From: Juan Baeza
Sent: 30 August 2011 12:36
To: Planning.Responses
Subject: FW: EG/33/11 Greenoaks, Barnham

From: Brian Holland
Sent: 18 August 2011 10:12
To: Juan Baeza
Cc: Jonathan Parsons
Subject: EG/33/11 Greenoaks, Barnham

RBA 895 - 50 P8

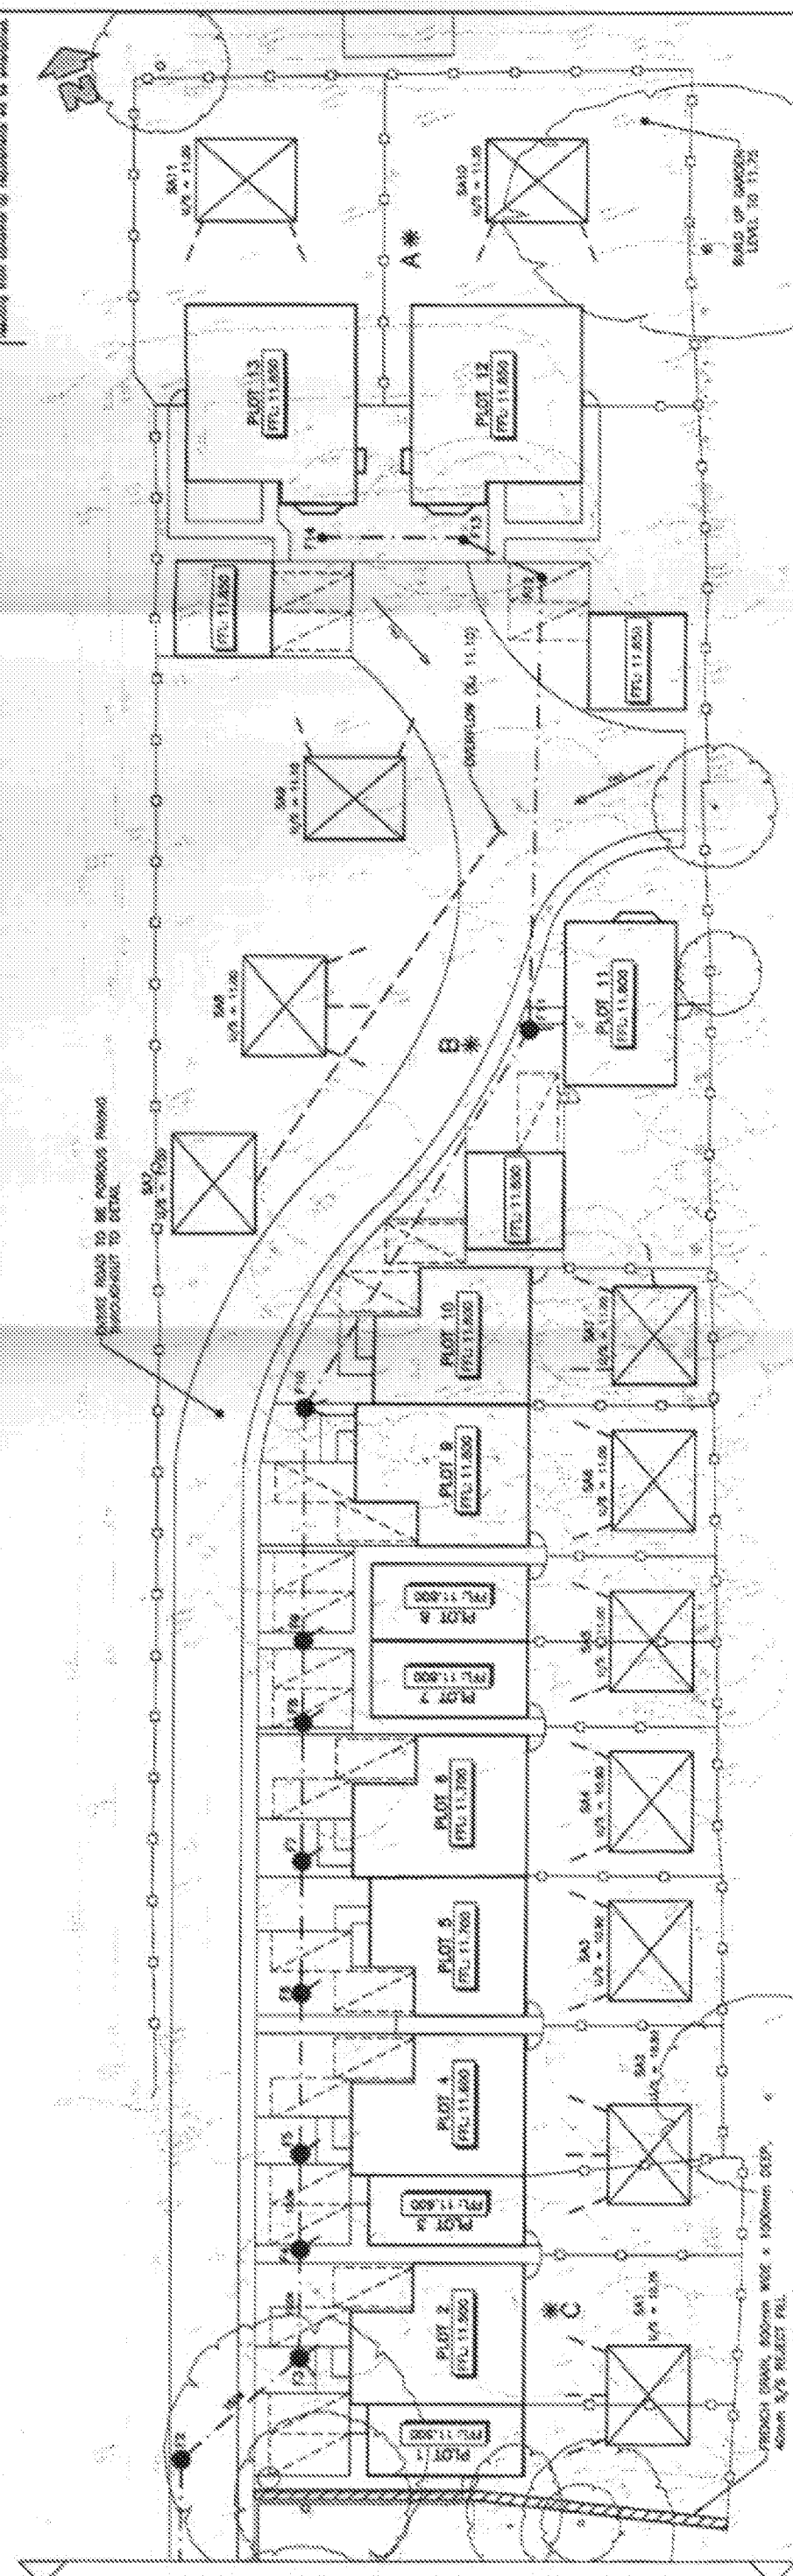
I am also considering the need for a 'NO DIG' zone in the rear gardens of these properties. To ensure the soakaways will work in the future there will be a need for no planting on and around the area of the soakaways which are each a nominal 30 m² in area. The soakaways are actually designed so that the top is at or above the surface level of the garden. How can such a requirement (no dig / no plants) best be incorporated to ensure long term adherence?
